from
**Southern
Water**

Our ref
PLAN-040929

Proposal: Outline planning application (with all matters reserved except for access) for the development of up to 1,500 dwellings (Use Class C3), 60-bed care home (Use Class C2), up to 9,000 sqm of employment floorspace (Use Classes B1), local centre of up to 2,350 sqm including up to 900 sqm retail / commercial (Use Classes A1-A5) and 1,450 sqm community / leisure floorspace (Use Classes D1-D2), land for a two-form entry primary school (Use Class D1), public open space, allotments, new sports pitches and associated facilities, drainage, parking and associated access, infrastructure, landscape, ancillary and site preparation works, including demolition of existing buildings and part removal of existing runway hardstanding. This application affects a Public Right of Way. This application is the subject of an Environmental Statement. This application may affect the setting of a Listed Building. This application falls within CIL Zone 1 - Zero Rated.

Site: F/4/20/OUT: - Land at Ford, Airfield Ford, BN18 0HY.

-  Site Boundary
-  1.50µg/m³ Contour (Maximum)
-  3.00µg/m³ Contour (Maximum)
-  5.00µg/m³ Contour (Maximum)

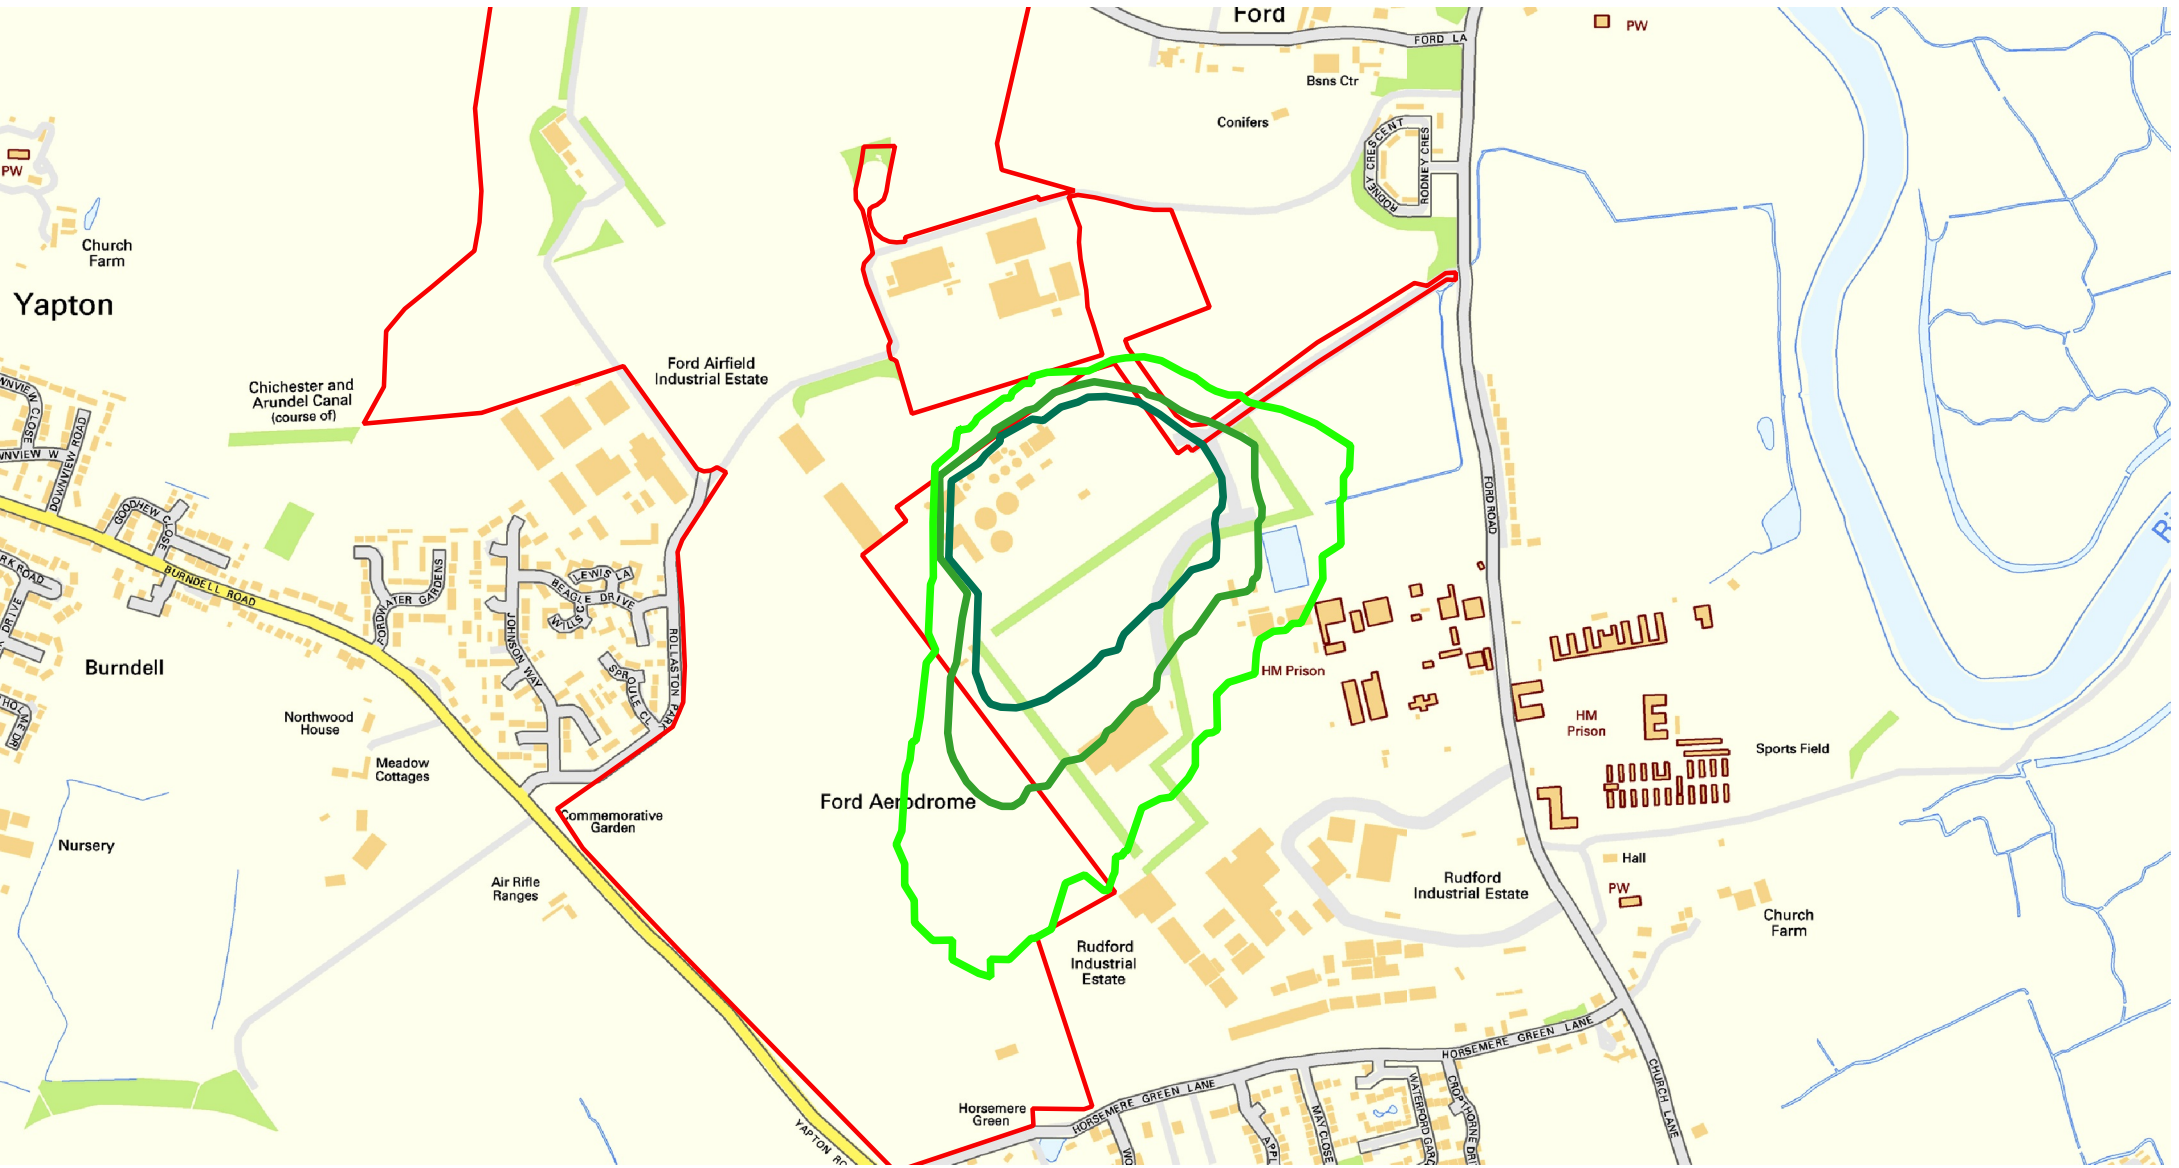
Southern Water would object to this development based on the odour assessment that has been submitted. There are two items which require us to maintain our objection, namely:

- Not adopting the Southern Water recommended odour standard. That is the adoption of a less stringent odour criterion ($3.0 \text{ ou}_E/\text{m}^3$) as opposed to that required by Southern Water ($1.5 \text{ ou}_E/\text{m}^3$).
- There is an issue with the sniff test results not aligning with the odour model.
